**Consultation Response from KC,
Highways Development Management**

2025/93438 Arena Young Peoples Centre, Moorlands Road, Dewsbury, WF13 2LF

Erection of 10-unit (class C2) special needs care home, day centre (class E(f), administration and training building (class E(g)(i)

FINAL Consultation response

Appendix 3 – Fire Tender Swept Path Analysis

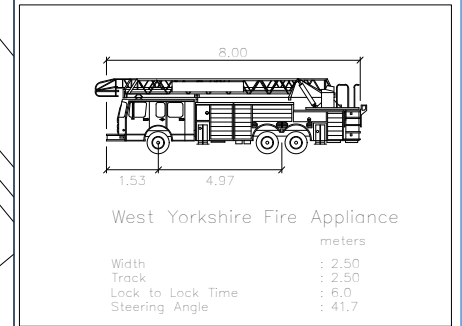
A turning head is provided on site that is suitable for vehicles up to mini-bus size and drawing number 6695 T1 01 rev 0 shows that an 8m West Yorkshire Fire and Rescue fire tender can turn on site and this is acceptable. Refuse vehicles would not be expected to enter the site and turn and so a bin collection presentation point has been located adjacent to Boothroyd Lane and this is acceptable to the Kirklees Waste Strategy team.
